Development Control
Ribble Valley Borough Council

App no: 23.1004

Address: The Hawthorns West Bradford Road Waddington

Proposal: Demolition of existing dwelling. Construction of replacement two-storey dwelling with rooms in the roofspace, single-storey annex and relocation of site access. Resubmission of 3/2023/0759

PROPOSED SITE PLAN

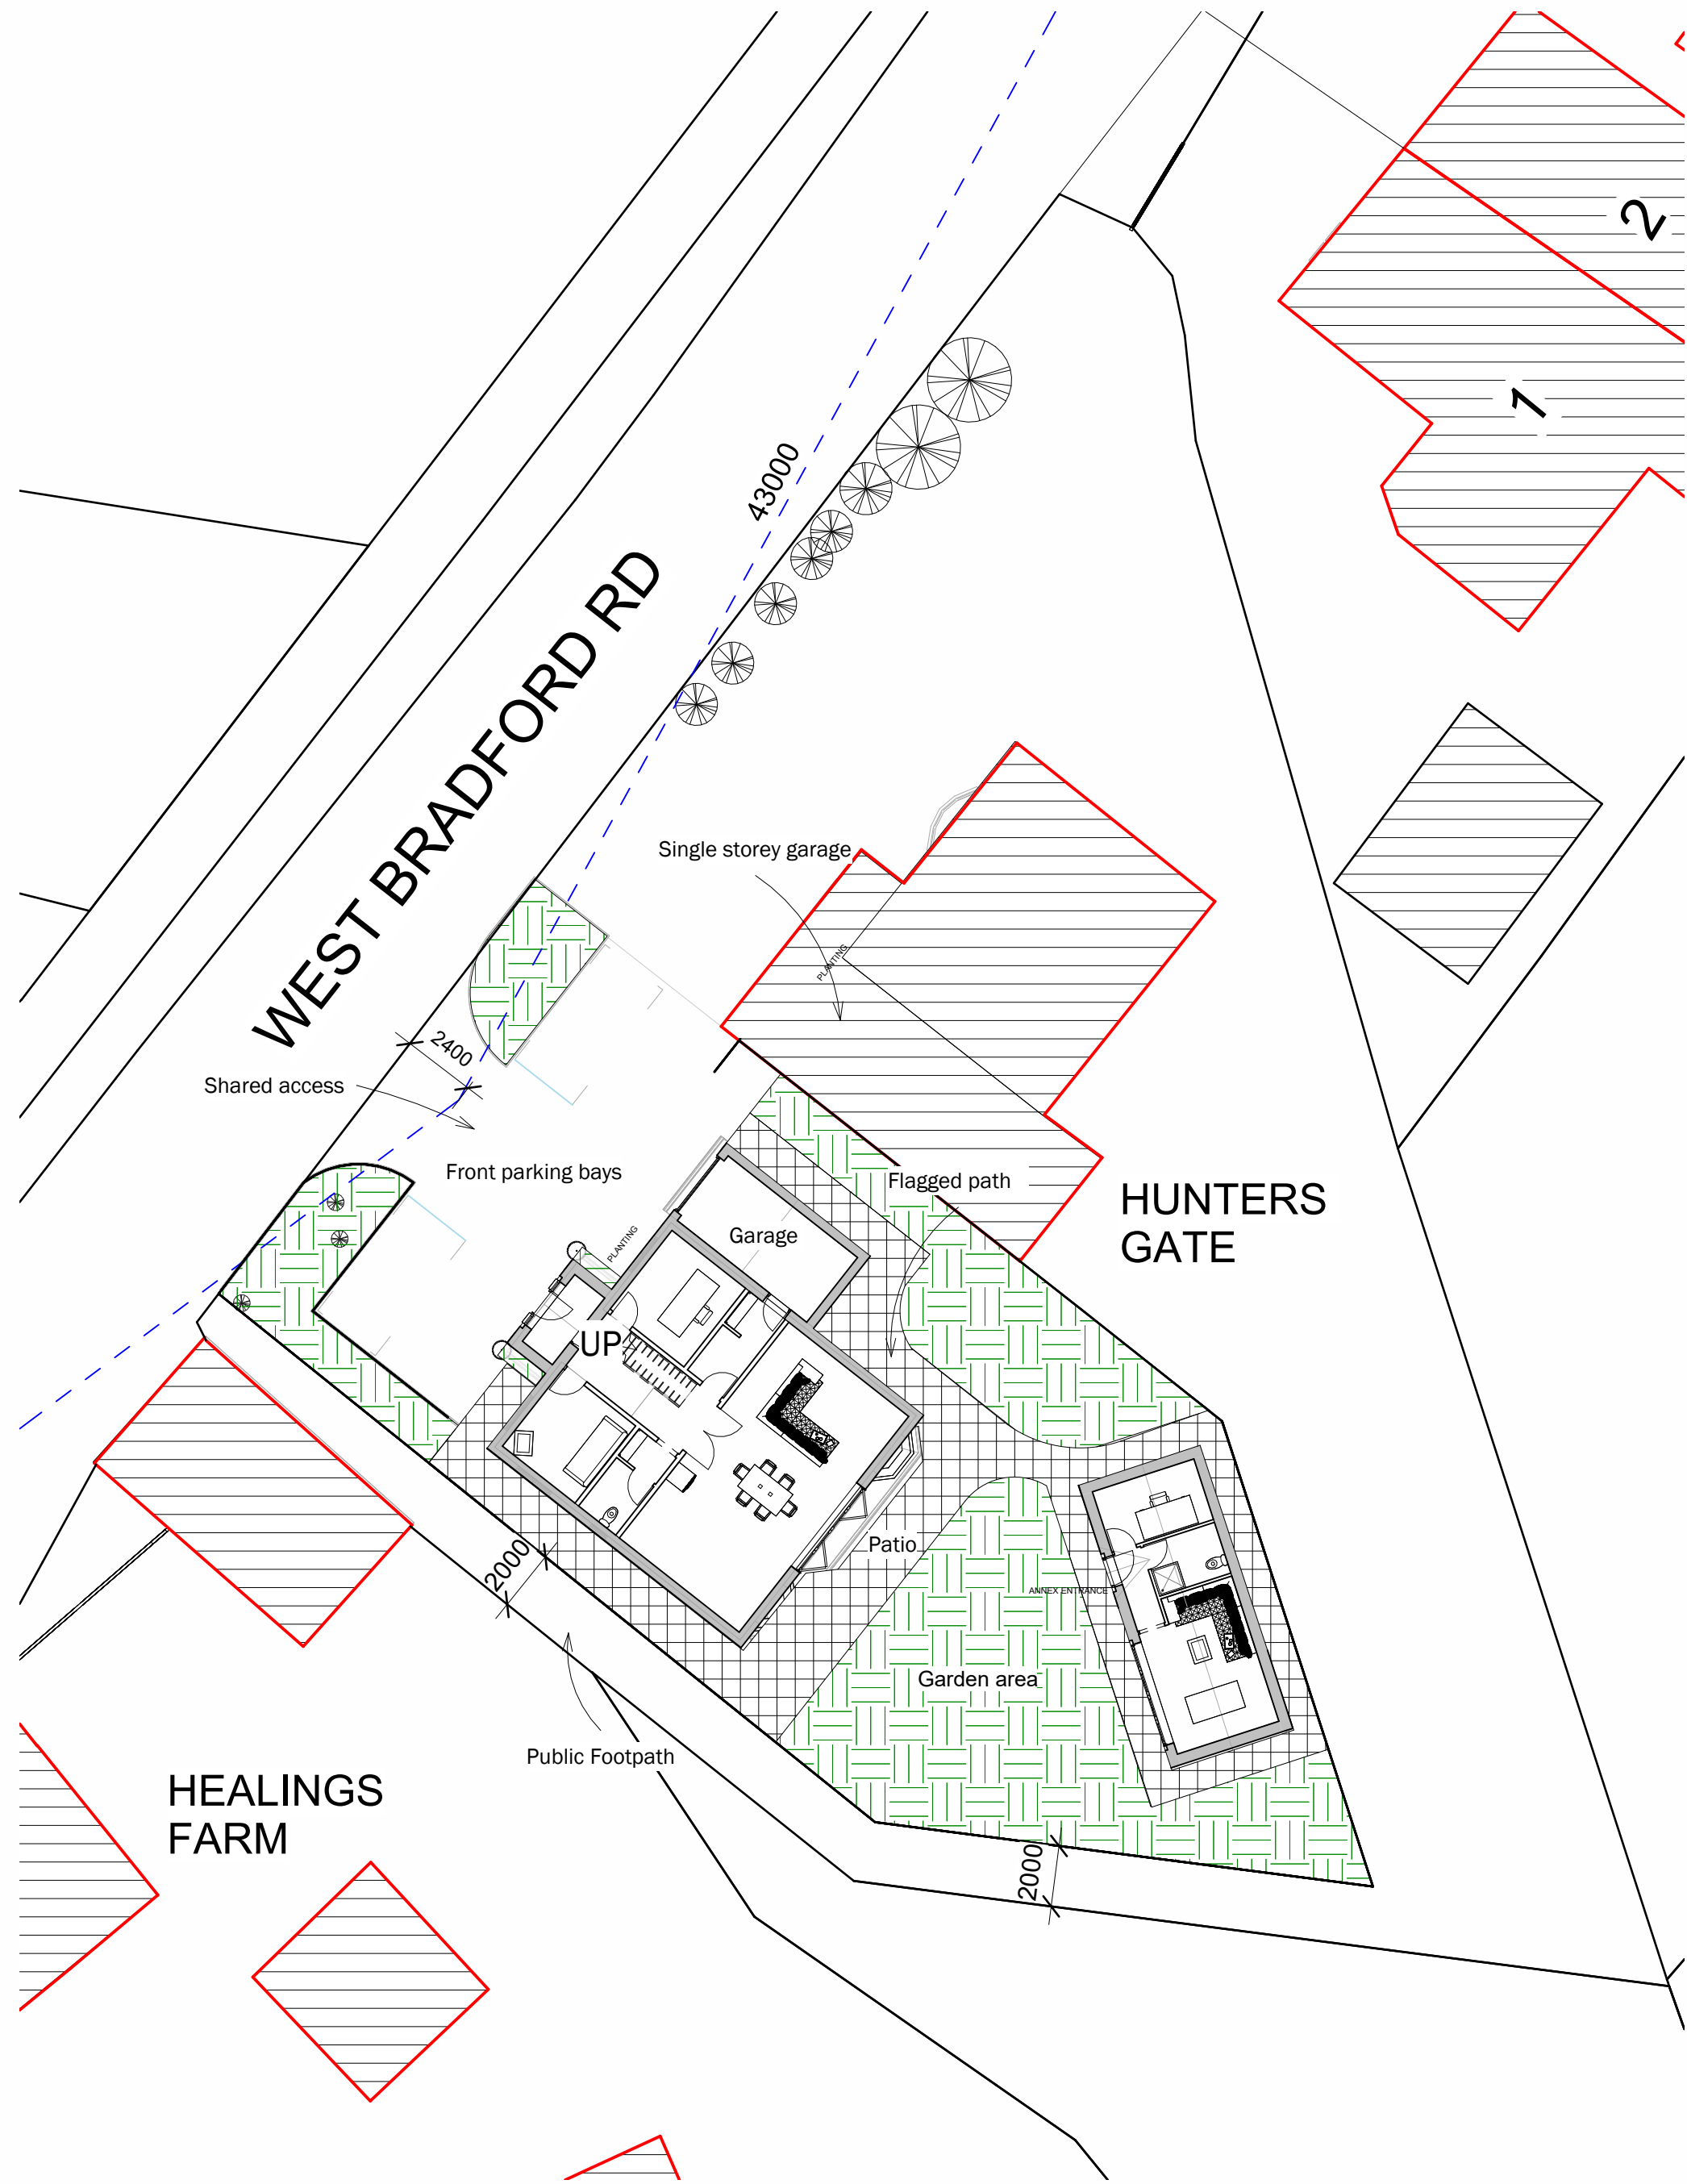
This application seeks the demolition of the existing dwelling and the erection of a single 4 bedroom dwelling and detached 1 bedroom annex. There is a new access proposed to serve 3 driveway car parking spaces and a single garage. The garage is smaller than the recommended internal size of 3m by 6m therefore it is not

counted as a parking space. There is however space in front of the garage for a fourth car. The garage would count as secure cycle storage.

The same site access and parking arrangements are proposed for this application as were proposed for the previous application. This is considered to be acceptable for the 1 x 4 bedroom dwelling and the 1 x 1 bedroom annex.

A condition is requested to ensure that the boundary treatments are kept below 1m high to ensure that the visibility splays are protected.

It is noted that the public footpath FP0343023 is currently routed along the southwestern boundary of the site. The proposal includes the widening of the route to 2m wide. Details of the surface construction will need to be submitted for approval and they will need to tie into the existing construction and provide adequate edge restraint along the site boundary. These works will require the temporary closure of the footpath for the safety of the users. This must be agreed with Lancashire County Council Public Rights of way team in advance of any works.

1. Prior to first occupation of the development hereby permitted, the site access shall be formed with a concrete kerbed edge along the carriageway of West Bradford Road and radii kerbs in accordance with the approved plans and Lancashire County Councils specification. Reason: To ensure adequate restraint for the carriageway construction and site access for highway safety.

2. Prior to first occupation of the development hereby permitted, the site access and parking spaces shall be surfaced in a porous, bound material. Reason: To ensure no debris or surface water is deposited onto the highway for highway safety.

3. Prior to the commencement of any works to widen the public footpath a construction specification should be submitted for approval including a timetable of works and temporary closure of the footpath. The works should be completed within the agreed timetable. Reason: To protect the footpath users for highway safety.

4. The entire boundary treatment along West Bradford Road and along the public footpath FP0343023 for the first 2m and along the boundary of the neighbouring dwelling named Hunters Gate for the first 2m shall be provided and maintained below 1m high. Reason: To ensure adequate visibility splays are provided for highway safety.
